Your Ref: OWPC15470
Our Ref: R/184/17/PD 08-08-2017
Please ask for:
Mrs A Gardner

Notification for prior approval under class C for a change of use from a shop (Class A1)
to a restaurant/cafe (Class A3)
51 Sea Lane Rustington

**APPENDIX ONE:
DRAWING SHOWING EXTERNAL EXTRACT AND VENTILATION EQUIPMENT PROPOSED**

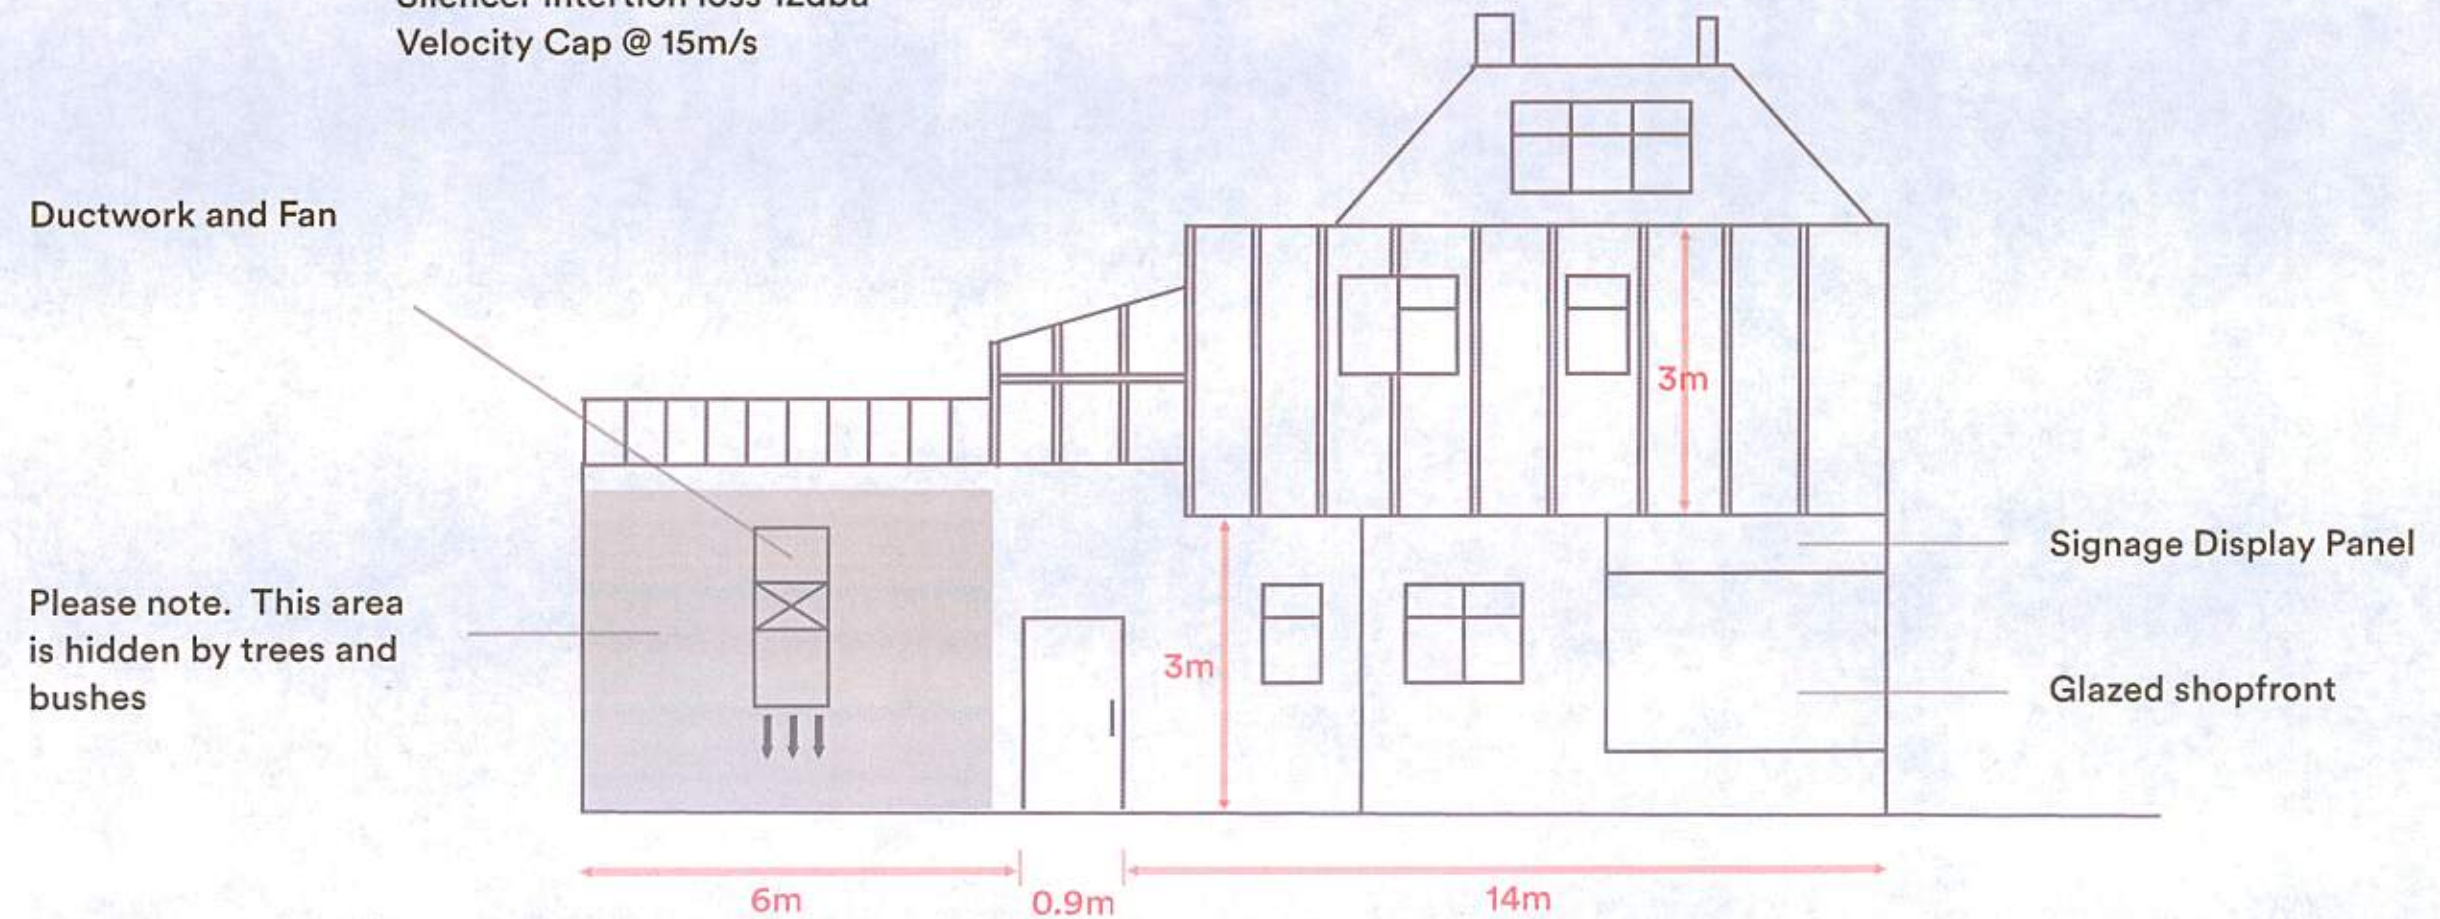
After looking at the plans my main objection is the car parking. It is already very difficult to park in front of the parade of shops and the additional traffic would make it even more difficult getting out on to Sea Lane from Cudlow Avenue.
Also looking at the Extract system for the Kitchen the plans indicate it being positioned behind trees and bushes, this however will not stop the unpleasant smells reaching the properties in the immediate vicinity. This Extract system indicates the exhaust fumes being directed down, when most Exhaust systems from Kitchens direct the exhaust upwards into the atmosphere. Directing it down just makes the situation worse. I would also say that at present in Rustington we have enough Cafes and eating places.
Therefore I object to this application for the reasons stated.
